Recommendation Report for Lawful Development Certificate for a Proposed Use or Development

REF NO: P/51/20/CLP

LOCATION: 26 Drift Road
Pagham
PO21 3NS

PROPOSAL: Lawful development certificate for removal of existing single storey extension and replace with new single storey rear extension, removal of chimney and replace with velux window.

PROJECT: 26 DRIFT ROAD.
DRAWING NUMBER: 010520/TP03'A'
SCALE[S]: 1:500 + 1:1250 @ A4
DATE: 28.05.2020

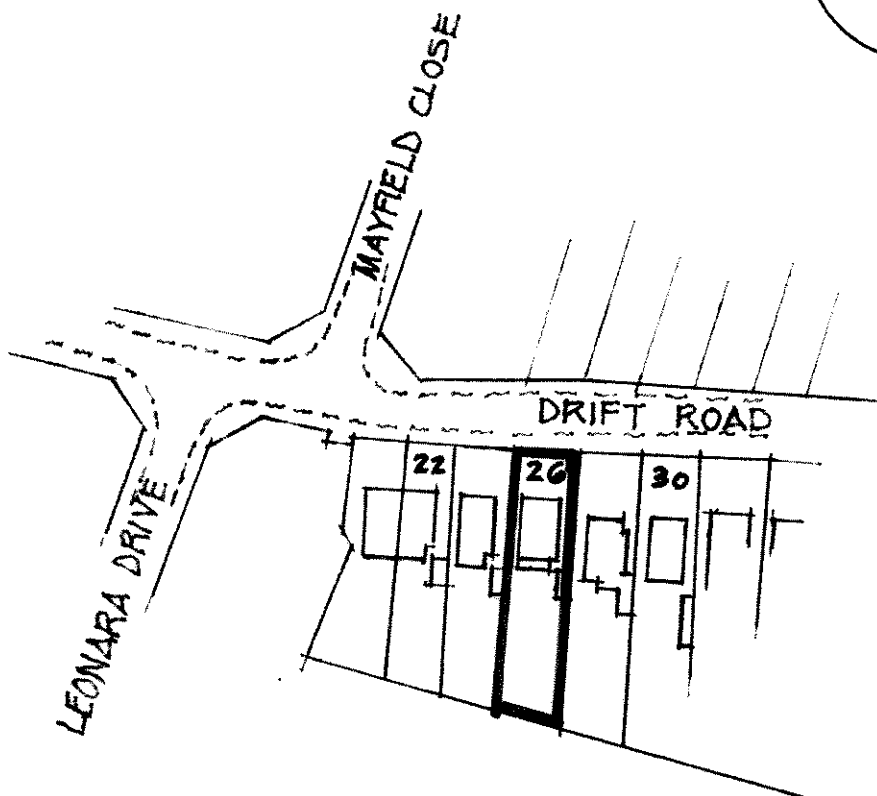
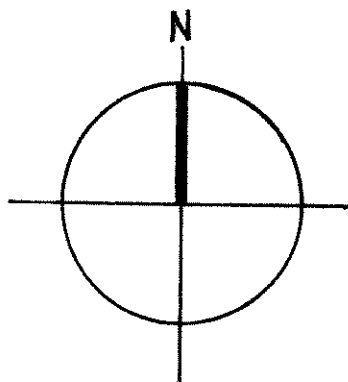
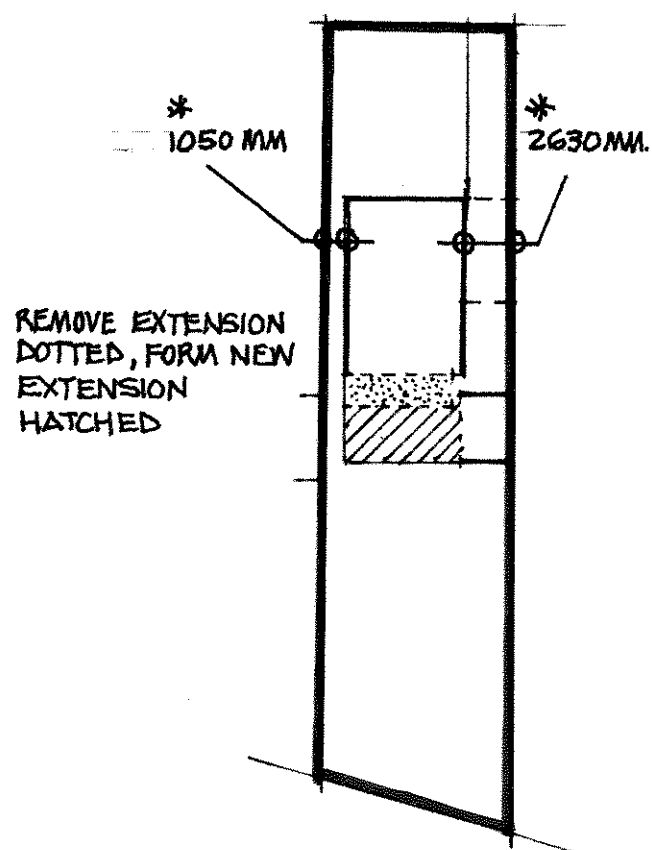
The proposed extension is considered to conflict with Schedule 2 Part 1, Class A (j)(iii) of the Town and Country Planning Permission (General Permitted Development) (England) Order 2015. The enlarged part of the dwellinghouse would extend beyond a wall forming a side elevation of the original dwellinghouse, and would -

(iii) have a width greater than half the width of the original dwellinghouse.

The proposed development also conflicts with the limitations in Schedule 2 Part 1, Class A (g) of the Town and Country Planning Permission (General Permitted Development) (England) Order 2015.

As part of (g) the larger single-storey extensions, extending beyond the rear of the original house by more than 4m and less than 8m if a detached house, are subject to a neighbour consultation scheme to assess the impact of the proposed development on the amenity of their property. The requirements of the neighbour consultation scheme are set out in paragraph A.4 of Class A.

- The development conflicts with Schedule 2, Part 1, Class A (j)(iii) of the Town and Country Planning Permission (General Permitted Development) (England) Order 2015. The enlarged part of the dwellinghouse would extend beyond a wall forming a side elevation of the original dwellinghouse, and would -
(iii) have a width greater than half the width of the original dwellinghouse
- The proposed development conflicts with Schedule 2, Part 1, Class A (g) of the Town and Country Planning (General Permitted Development) (England) Order 2015 in that it extends beyond the rear wall of the original dwellinghouse by 6 metres and no neighbourhood consultation scheme has taken place.

This needs to be completed on an application for a larger homes extension which allows for the neighbouring properties to be notified.

SIDE ELEVATIONS AS PROPOSED

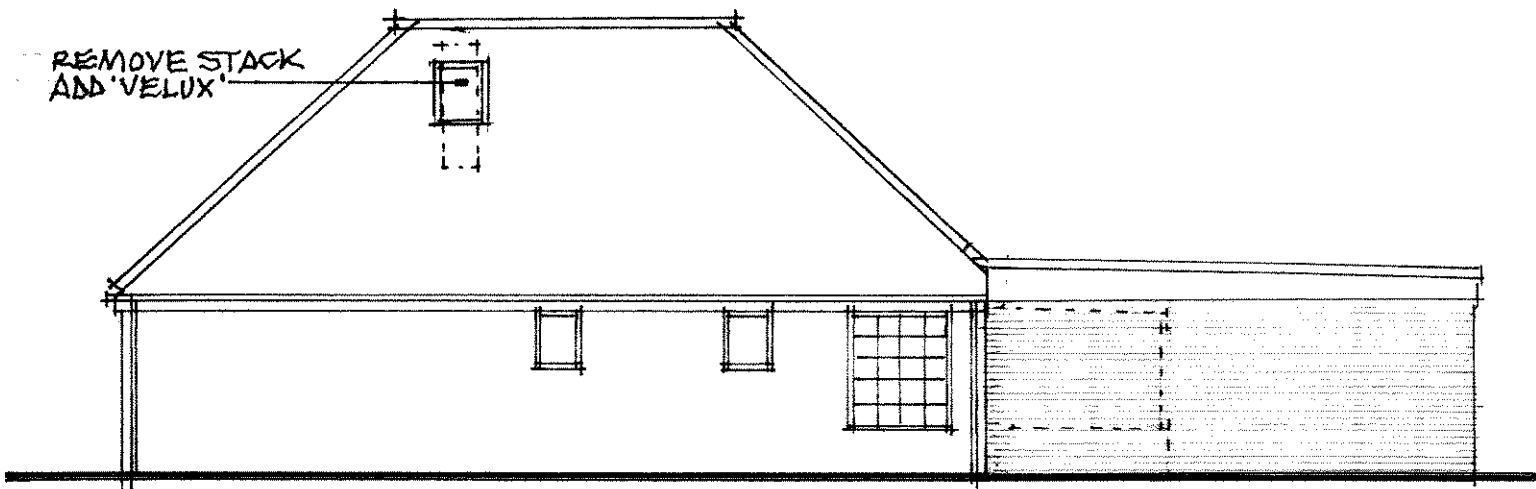
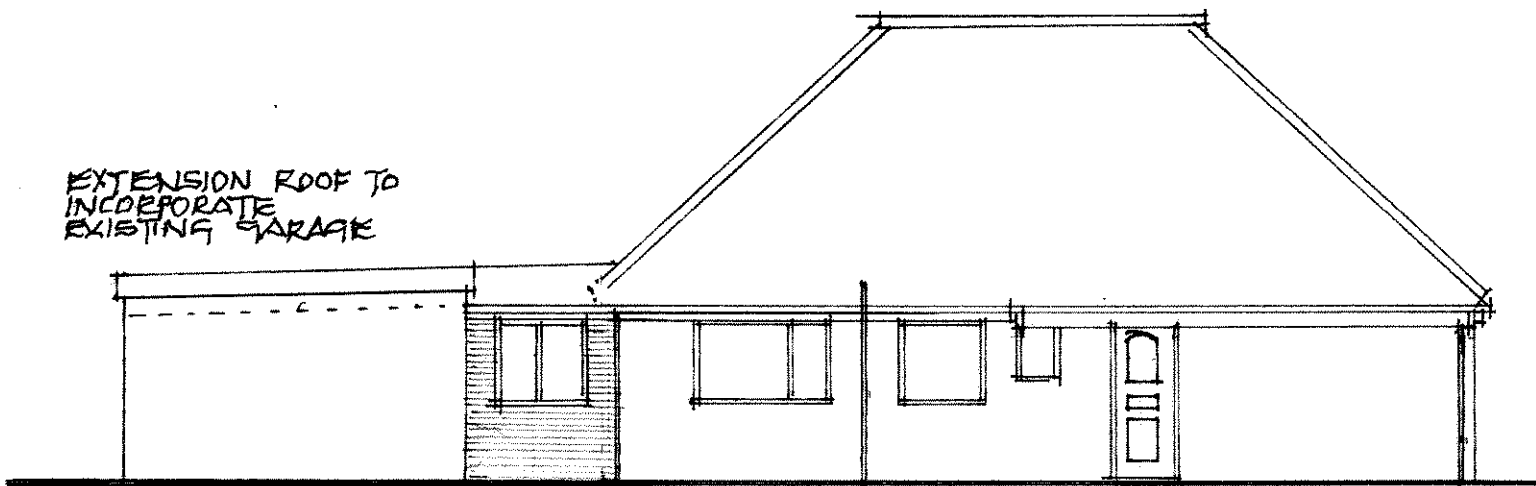
The proposed rooflight is considered to comply with relevant sections within Class C.
